re: **Response to City of Ottawa Comments**  
**Proposed High-Rise Building**  
**1330 Carling Avenue - Ottawa**

date: August 27, 2020

file: PG5157-MEMO.01

## Geotechnical Comments

Project	Mixed Use Building	###
	1330 Carling Avenue at Archibald	###
Drawing	Landscape Plan	###
Date:	MARCH 2020	Sheet Number
Scale:	1:100	<b>L1</b>
City of Ottawa	Dwg - #####	D07-###

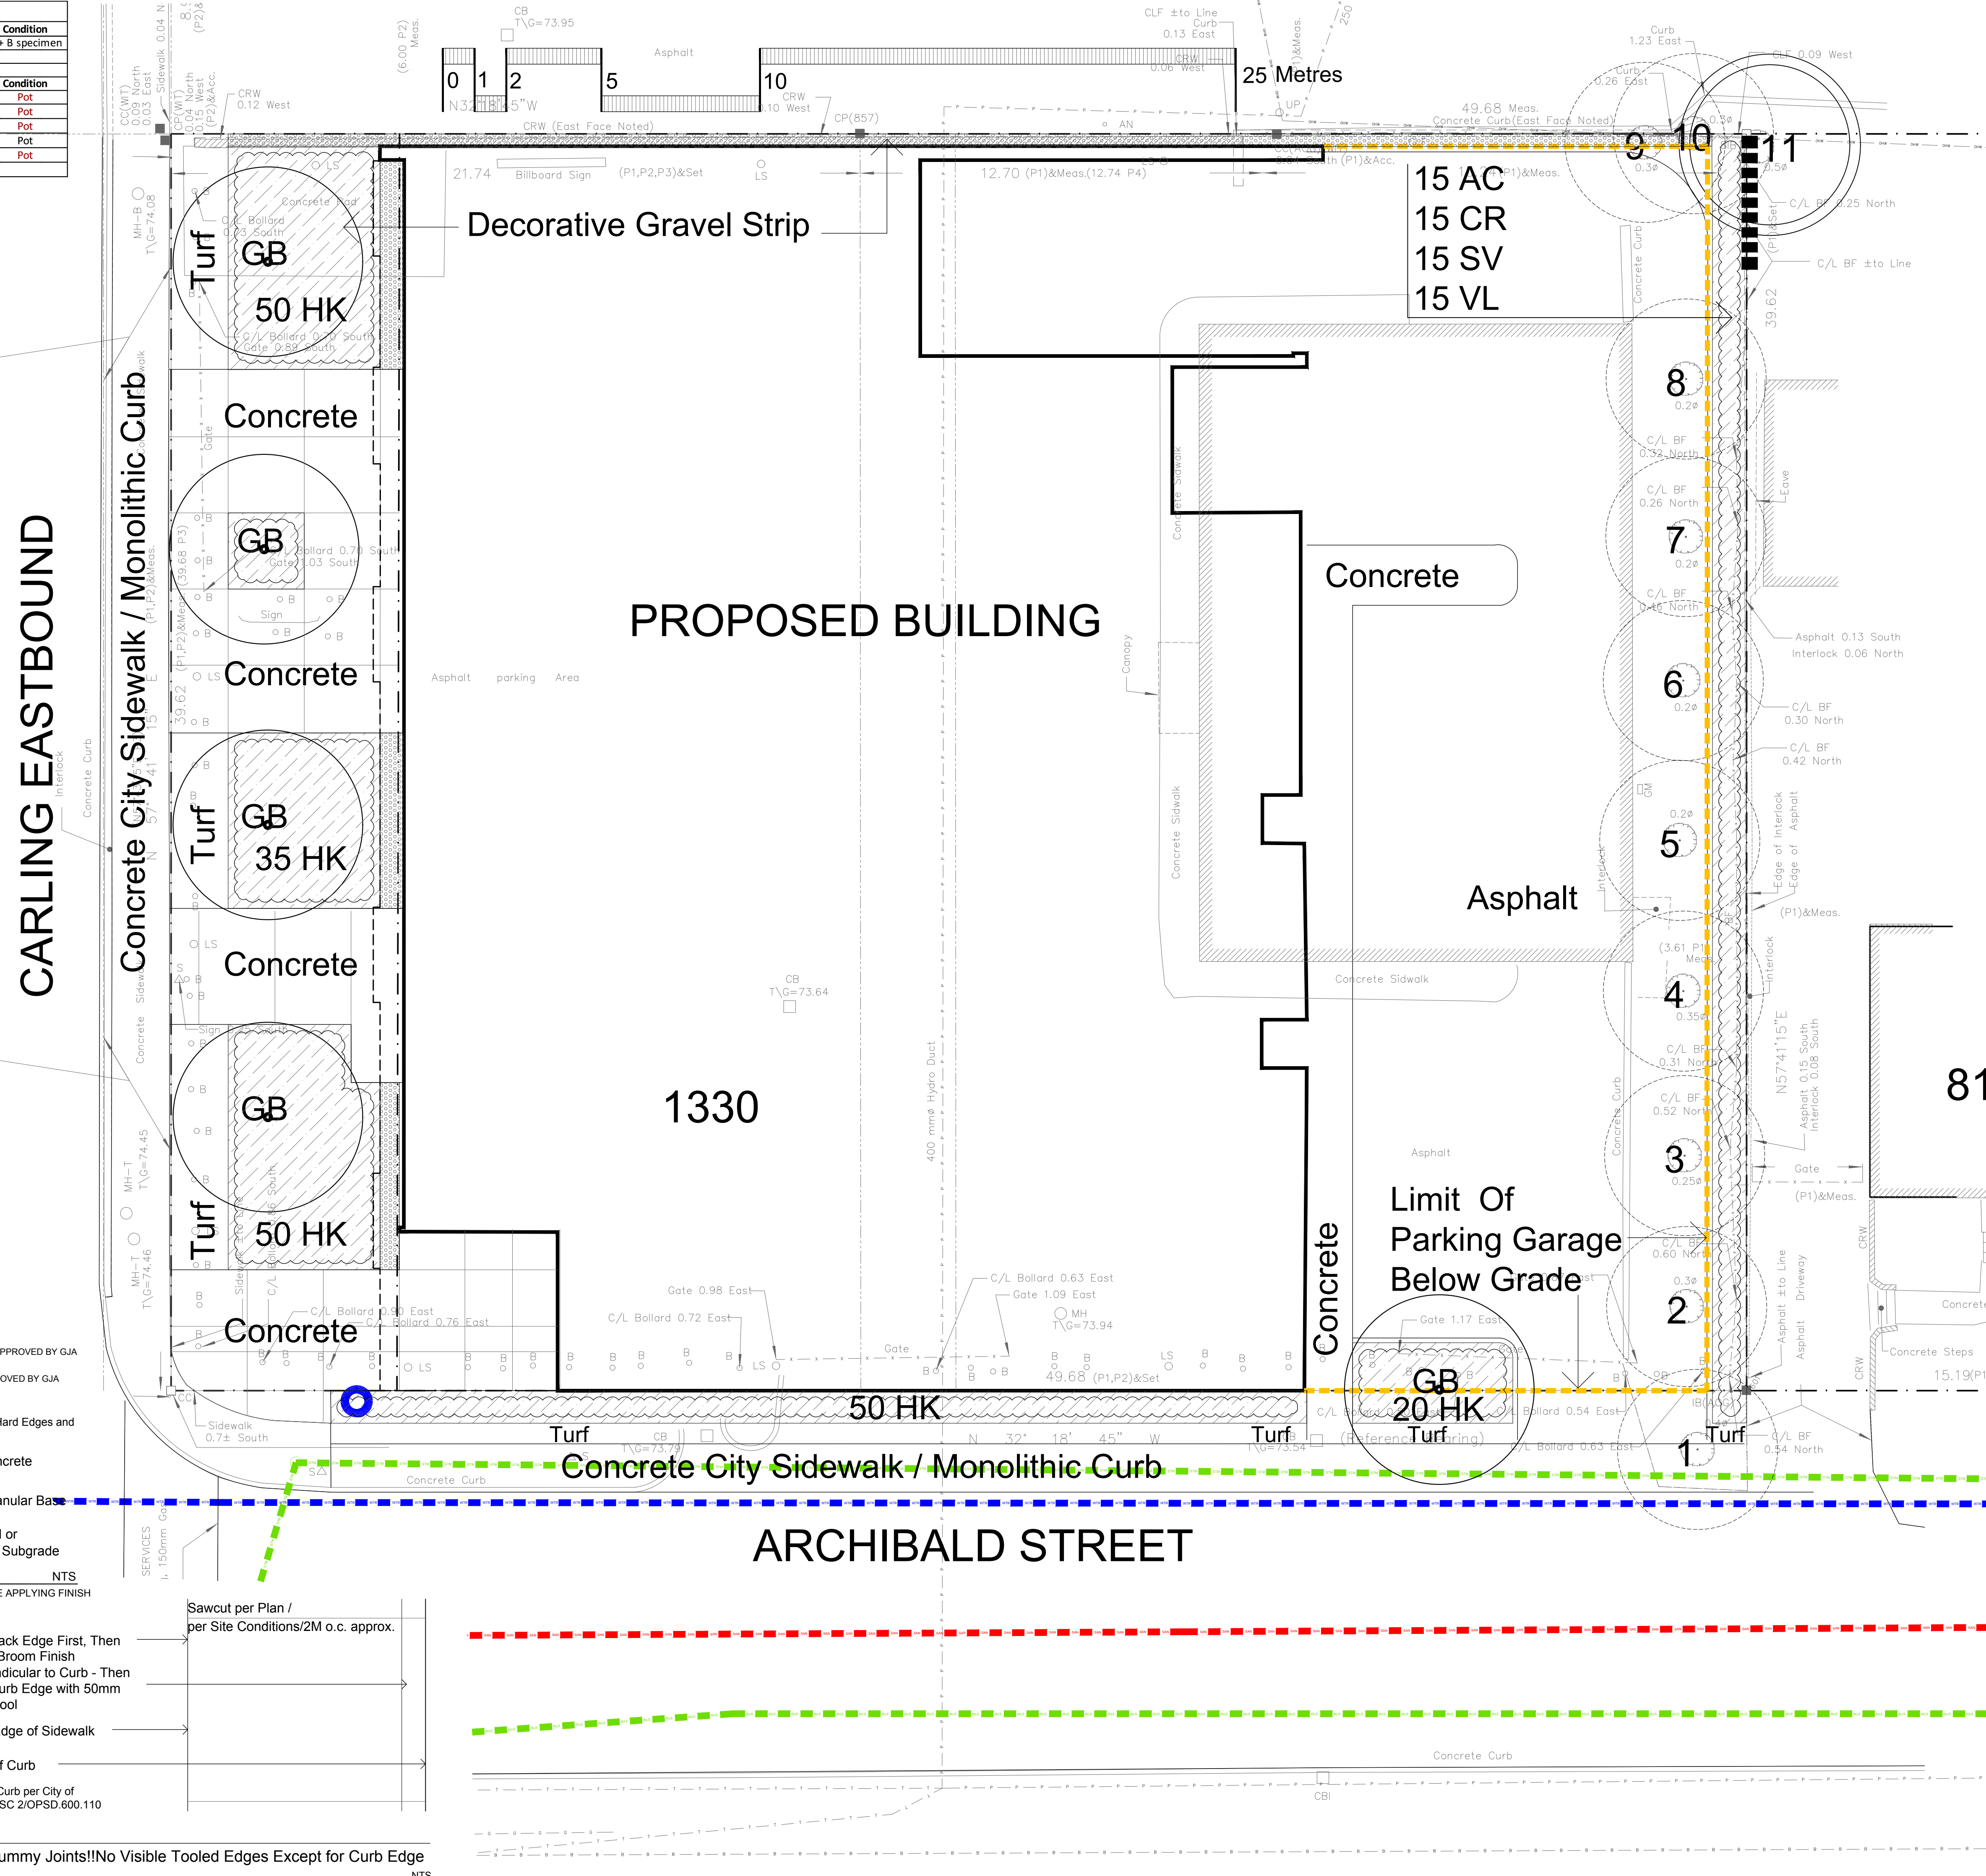
**Item B11:** *Provide Limitations of soil conditions for tree restrictions for the proposed development.*

**Response:** The subsurface profile encountered during our geotechnical investigation consisted of fill consisting of silty sand with gravel and cobbles over glacial till. The glacial till was observed to comprise of silty sand with gravel, cobbles and boulders followed by limestone bedrock. One borehole (BH 5) located outside of the building's footprint was observed to contain a thin layer of hard to very stiff silty clay.

The proposed building will host 2 underground levels. The underside of footing elevation of the proposed footings is expected to be well below the silty clay deposit. Therefore, due to the depth of the proposed footings along with the absence of silty clay below the proposed footings, no tree planting restrictions are required for the subject site, from a geotechnical perspective.
